Our Case Number: ABP-314724-22

Re: Railway (Metrolink - Estuary to Charlemont via Dublin Airport) Order [2022]
Metrolink. Estuary through Swords, Dublin Airport, Ballymun, Glasnevin and City Centre to
Charlemont, Co. Dublin

Re: Railway (Metrolink–Estuary to Charlemont via Dublin Airport) Order 2022
Case Reference Number NA29N.314724

Drawing Title	METROLINK - STRUCTURES CHARLEMONT STATION CROSS SECTION	Drawing Status	S0
Drawing N°	ML1-JAI-SRD-ROUT_XX-DR-Y-02097	Plan Drawing N°	ML-ST 307 O-A8
Scales Original Size A1	1 : 100	Sheet	8 of 8

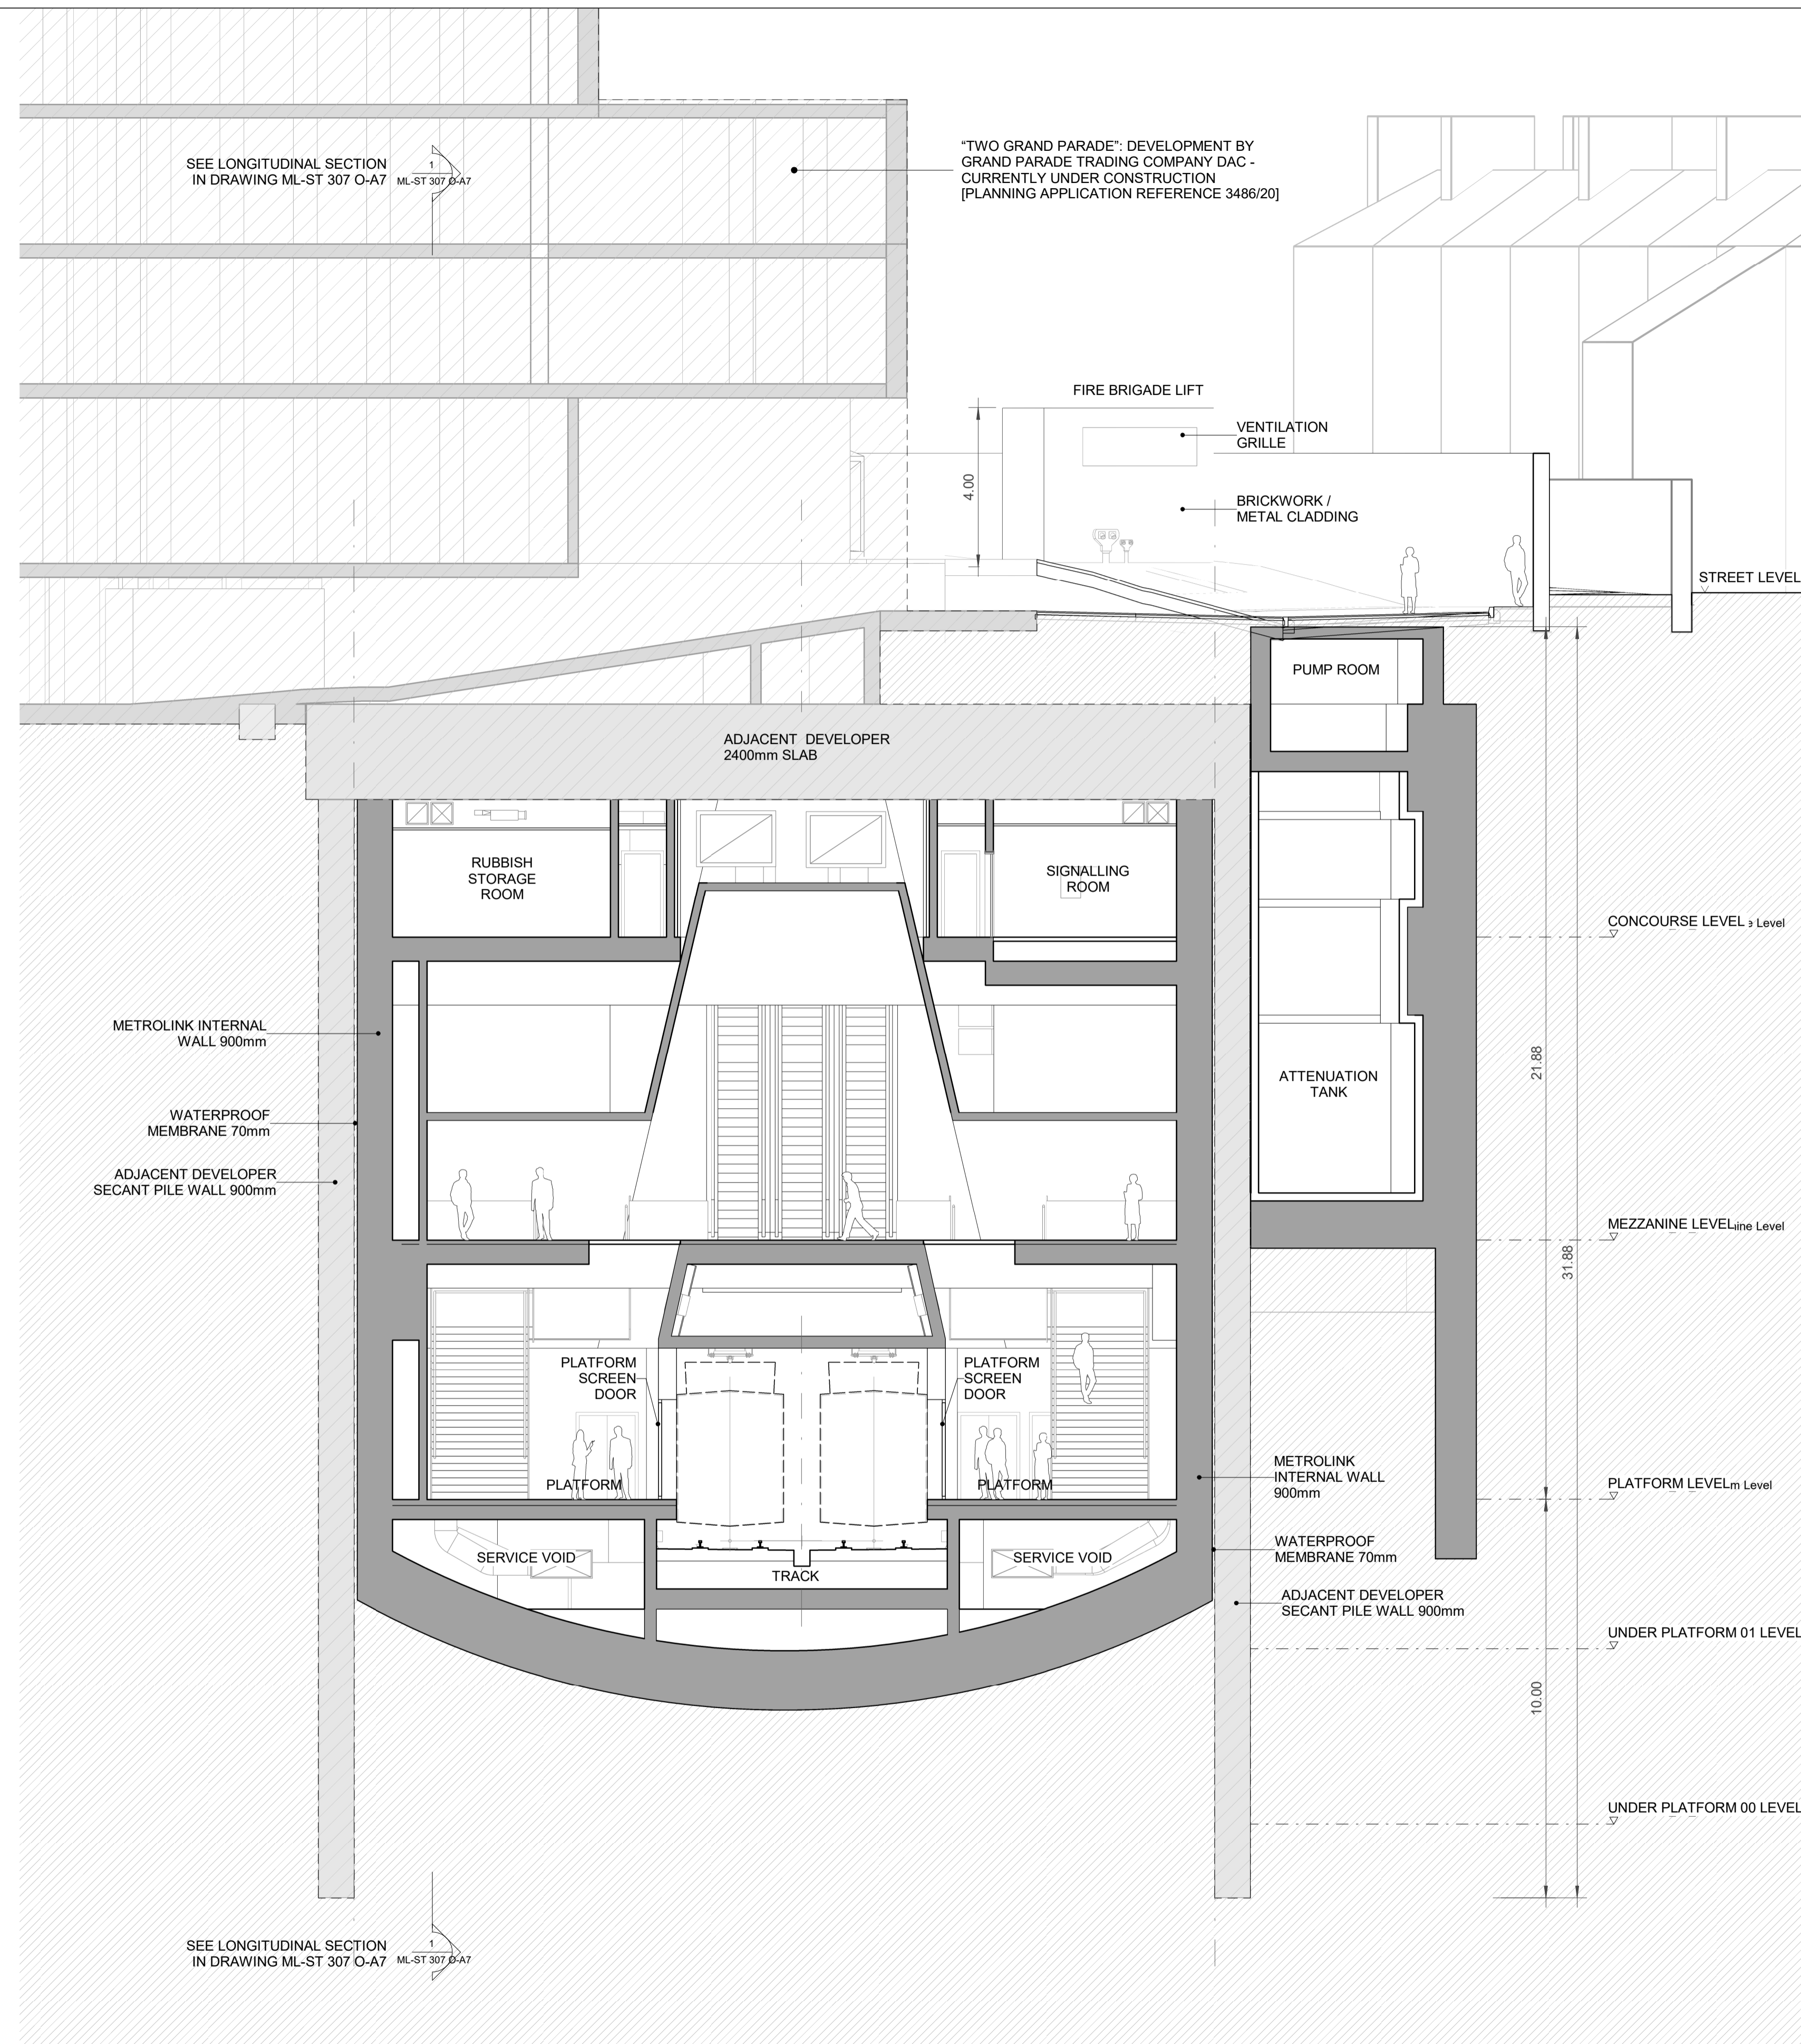
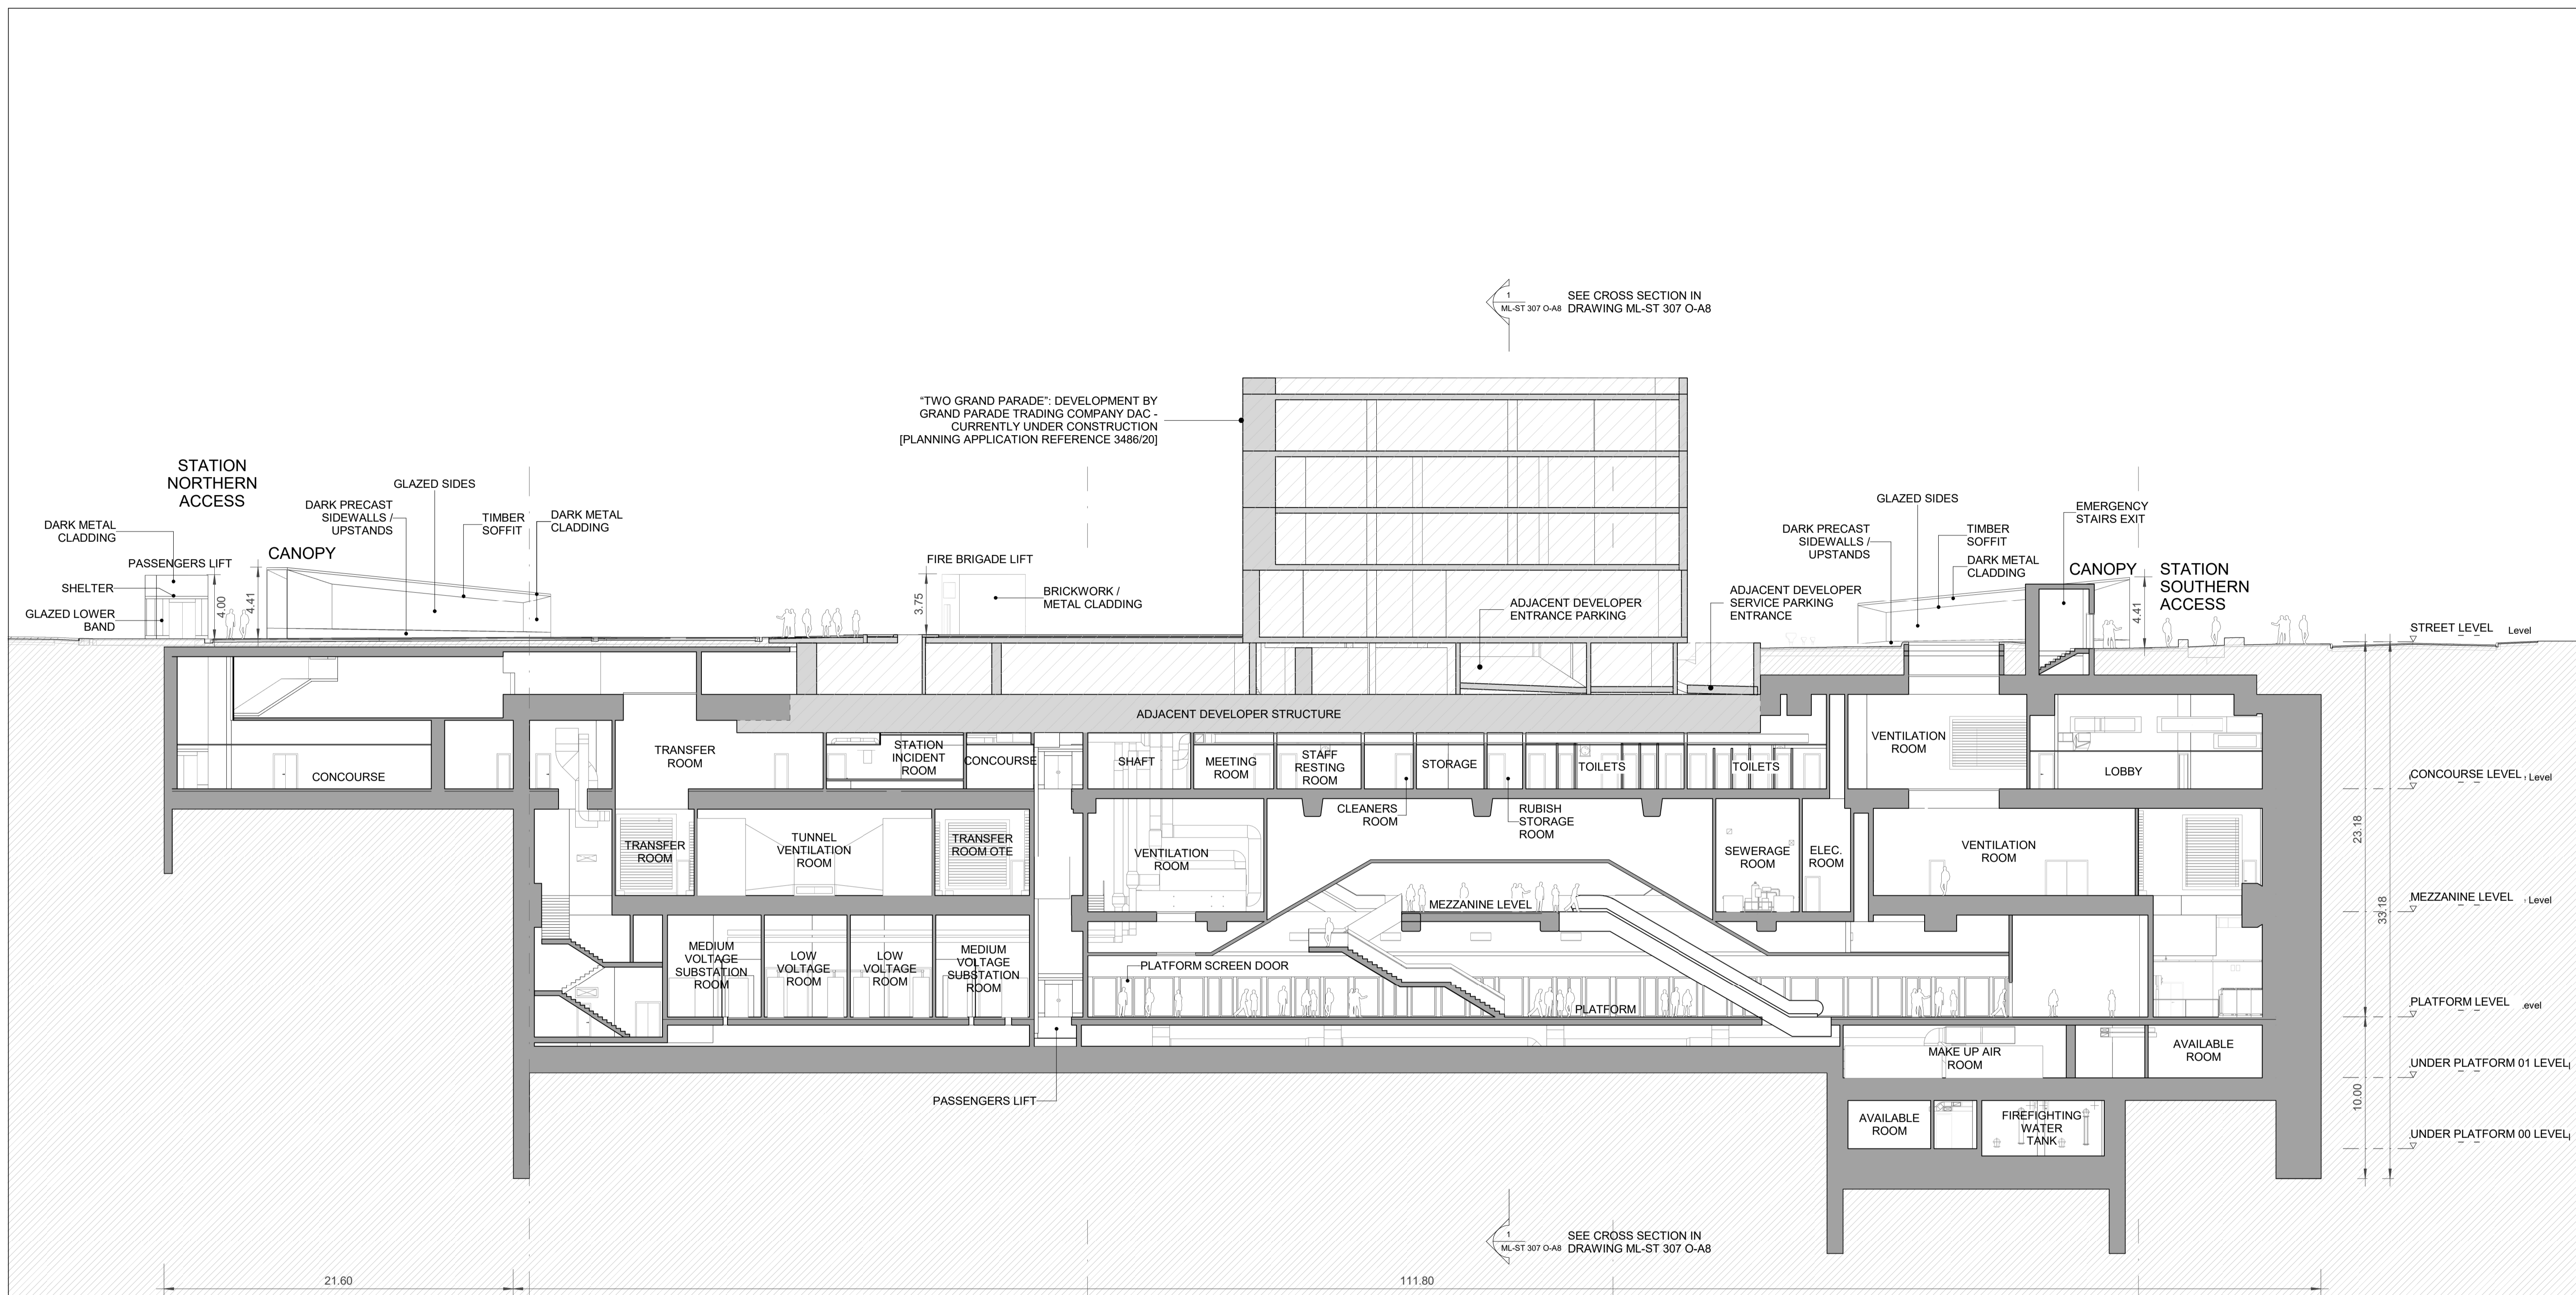
5. At the OH, our Structural Engineering expert, Mr Brian Kavanagh, stated that the level of ground settlement which TII had indicated would occur (up to 30mm) would severely damage the structural integrity of the Victorian 3-storey brickwork houses. It was also pointed out that settlement can be caused by the leakage of groundwater into the excavation, from the clay beneath the foundations; and to mitigate the risk of such settlement, the optimum method of preventing water ingress into the excavation should be used. We had understood from an earlier meeting with TII that their proposal involved the construction of a diaphragm wall (D-wall) prior to excavation. At the OH, it emerged that TII were keeping open the option of using a Secant Pile wall instead of using the more expensive D-wall, despite the admission by TII under questioning at the OH that the D-wall would be more effective.

6. At a meeting between residents of Dartmouth Square West and TII on 11 September 2024, TII presented a drawing showing a D-wall to the rear of some of the houses adjoining the excavation – but continuing on as a Secant Pile Wall behind other houses in the terrace. We expressed our concern, given the vulnerability of the Protected Structures, that they were not optimising their mitigation of the settlement risk; we requested that they consider changing the secant pile section by continuing the D-wall behind all of the houses on the terrace and around the entire excavation. They agreed to consider the request.

7. It further emerged at the meeting on 11 September that although TII were showing a D-wall on their drawings, the provision of the D-wall would not be a specified, mandatory requirement in the tender documents for the project; they intend to leave it to the discretion of the tendering contractor to propose an alternative method, which could be a secant pile wall. We stated that this would not be an acceptable mitigation of the risks to our houses and asked them to consider specifying the D-wall as obligatory in the tender documents. They agreed to do so.

2. Condition the Railway Order to require that the D-wall method of construction must be used around the excavation of the station box;
3. Condition the Railway Order to require that TII indemnify the residents of Dartmouth Square West against all loss and damage with a guarantee to pay the full costs of whatever repair or rebuild might be necessary to restore our houses to their original condition; and
4. Condition the Railway Order to require that TII provide a triple-glazed solution for the rear windows of the houses in Dartmouth Square West.
